From: Nia Russell [REDACTED]
Sent: 23 October 2017 11:52
To: Michael Eastham
Cc: Arfon Hughes
Subject: Fwd: Saltbox, Bognor Regis - Heads of Terms

From: karen jenkins [REDACTED]
Subject: RE: Saltbox, Bognor Regis - Heads of Terms
Date: 23 October 2017 at 11:04:11 BST
To: Arfon Hughes [REDACTED]
Cc: Nia Russell [REDACTED] Reg Kirk [REDACTED]

In Nia's absence, there are just two design details that have arisen regarding the Unit 2 Warehouse:

Drawing Title: PRELIMINARY DRAINAGE STRATEGY
SHEET 5 OF 9

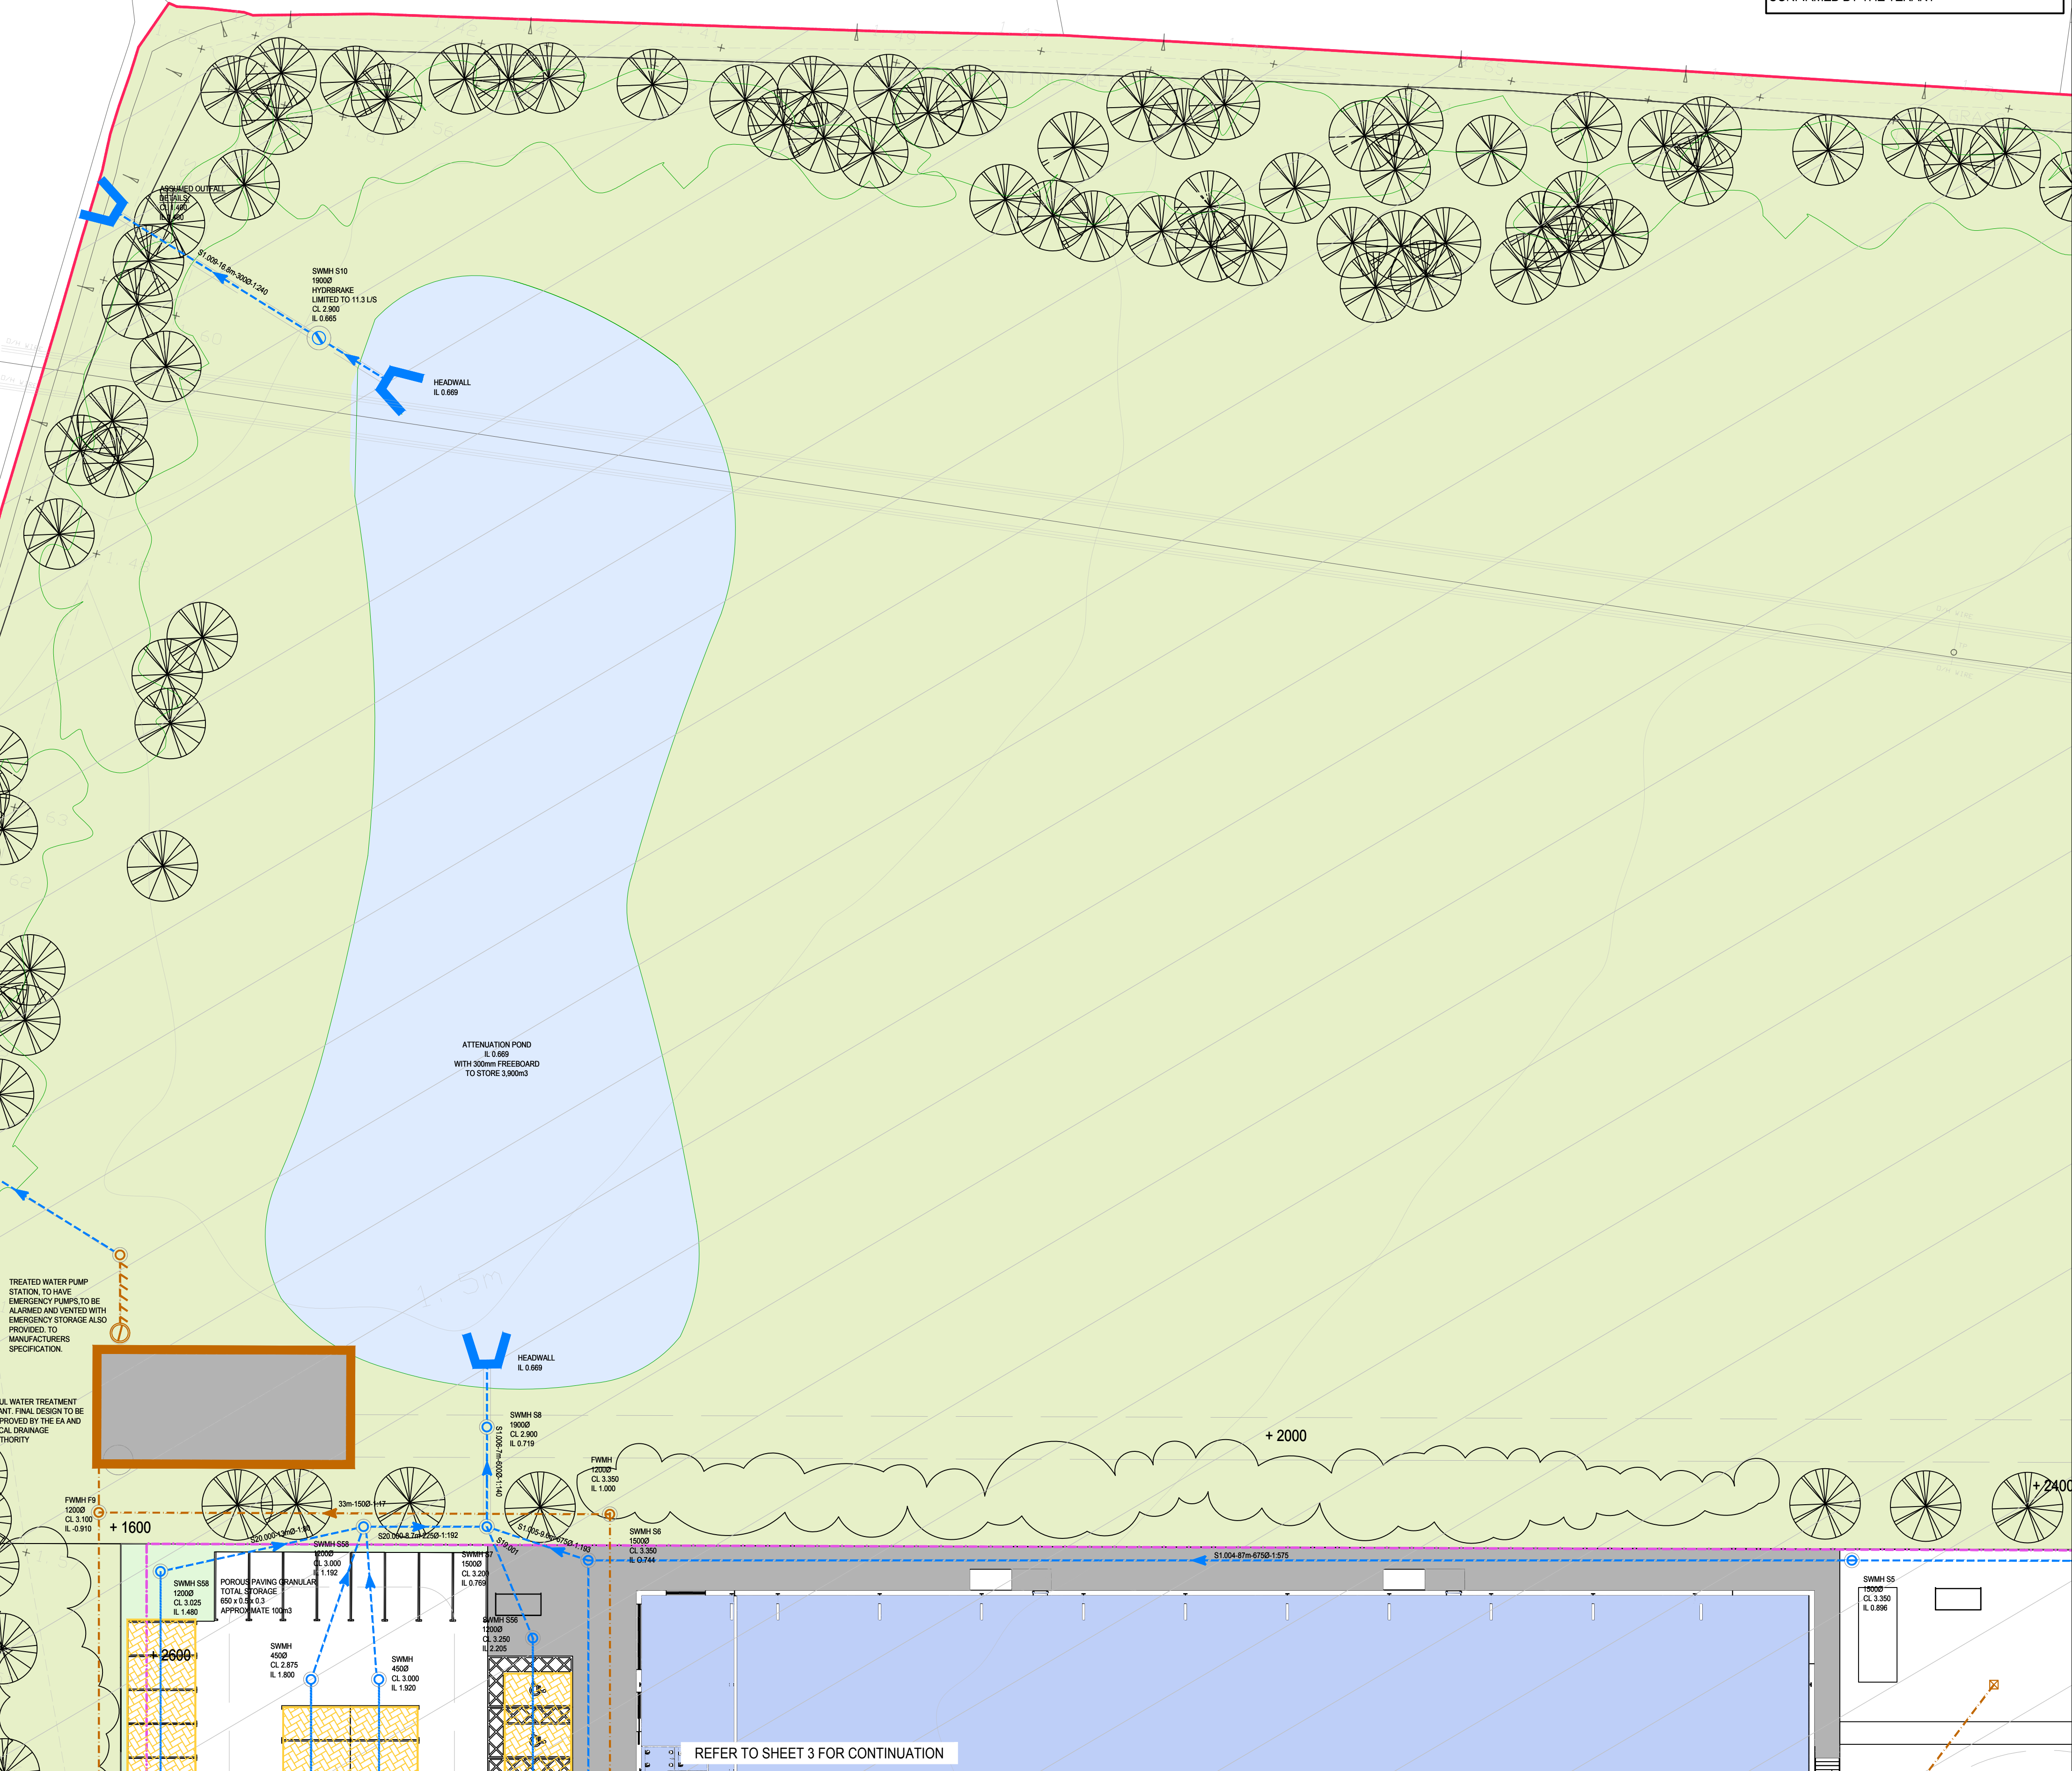
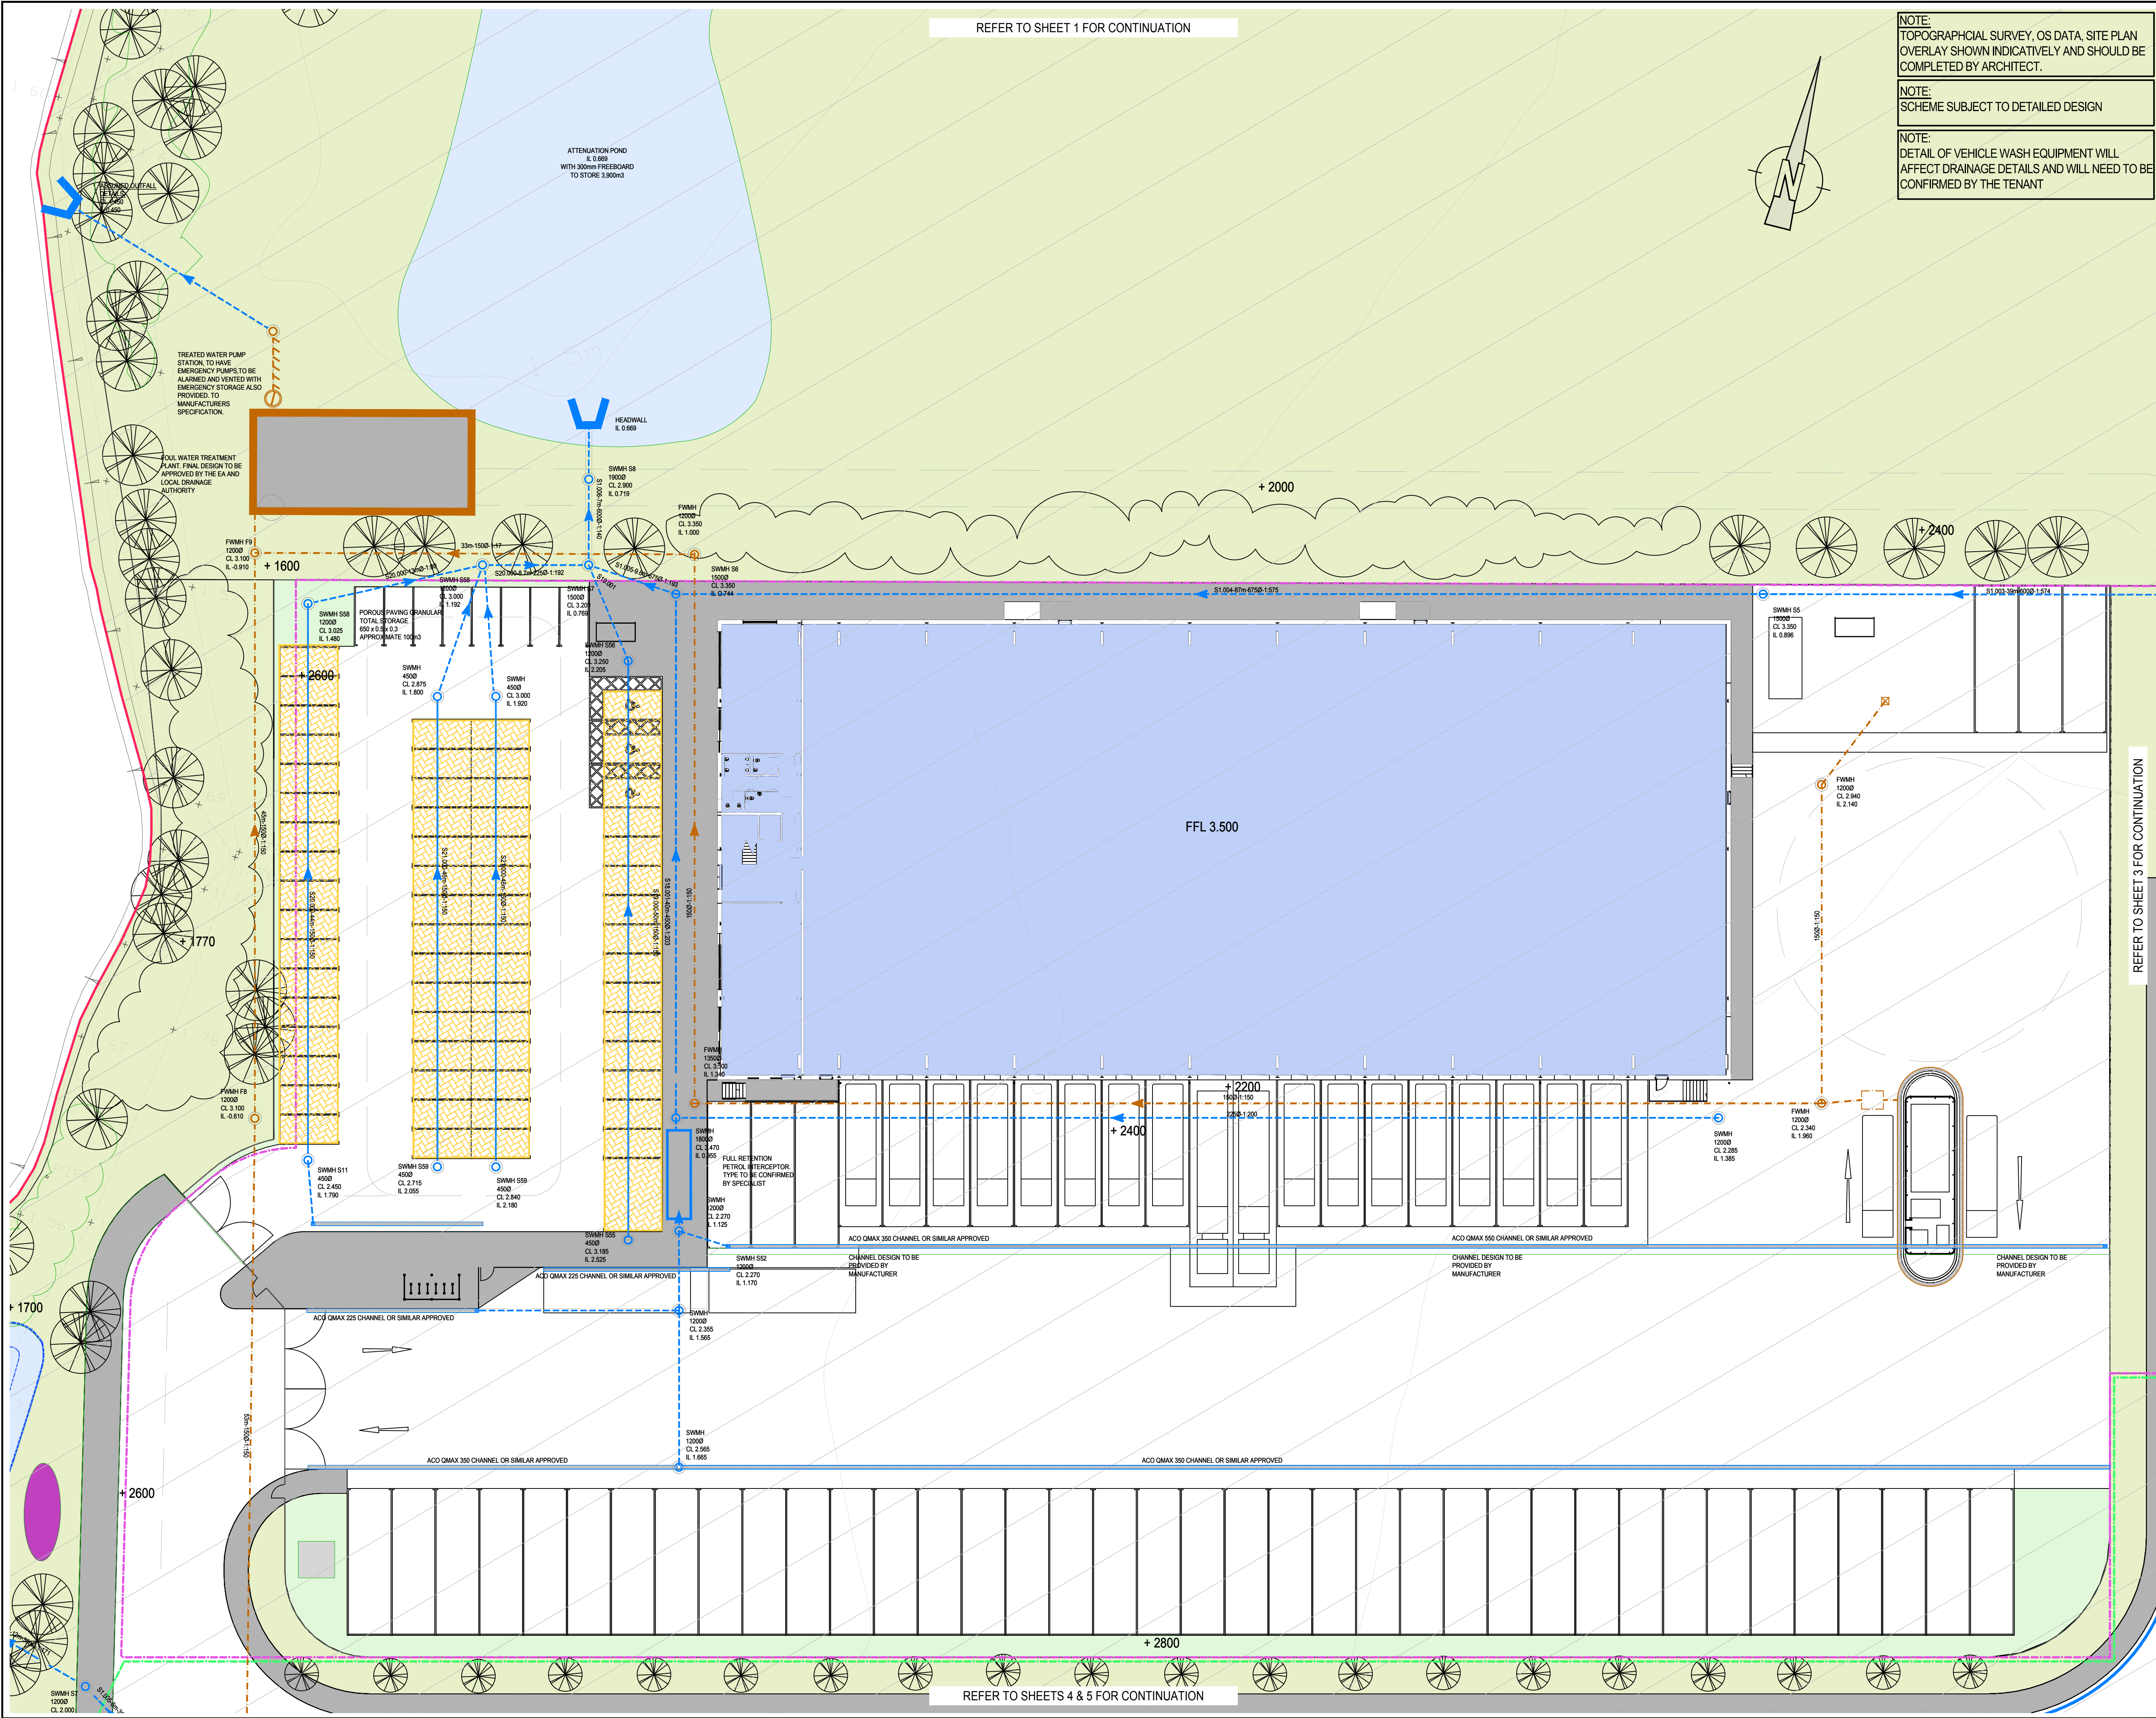
- 3) The Environment Agency normally discourages the use of on-site water treatment plants. Do you need an on-site water treatment plant?

For the Saltbox parcel (which forms part of the Bognor Enterprise Zone), Southern Water, as the local water authority, were contacted and confirmed that there is currently no means of disposal for the foul water at the site, and the local sewerage infrastructure does not have capacity to take the proposed foul water flows from site. If a site has no means of drainage to an existing public sewer due to third party land, the developer can formally request a new public sewer. This means that the water authority can provide a foul water sewer to serve the site.

A S98 solution was been prepared by Southern Water in May 2015 for the site, that indicates costs associated with a pumped system. Based on the information within the report, 674m of a 2m deep rising main and assuming £1000/m construction cost. The works are therefore valued at CRICA £700,000 which is to be paid by the developer. Based on this value, it is not financially viable for the development to progress with the Section 98 Application. In addition, based on other similar schemes, it is estimated that the S98 design process will take between 52-78 weeks before works can start on site.

Initially, a 3 stage wastewater system is proposed for the Saltbox site to deal with the foul water flows. The sewage is first settled to remove the solids and then biologically treated in an aerated biozone, consisting of rotating discs, or air injection, with a final settlement stage to remove the fine solids. The effluent is discharged, on average, 95% clean, to a land drainage system, then finally the watercourse, (subject to Local Authority and Environment Agency Consents).

The treatment system must meet the relevant British Standard at the time of installation. The standards currently in force for new systems are BS EN 12566. The clean treated discharge is subject to Environment Agency 'Consent to Discharge', prior to any flows being discharged directly the watercourse.

It is anticipated that the foul water treatment plant will be overall more financially viable for the scheme, although the final costs are still TBC. In relation to the programme, it is expected will take less time to implement. Hence, is the preferred option for the disposal of foul water sewerage from the proposed Saltbox site.
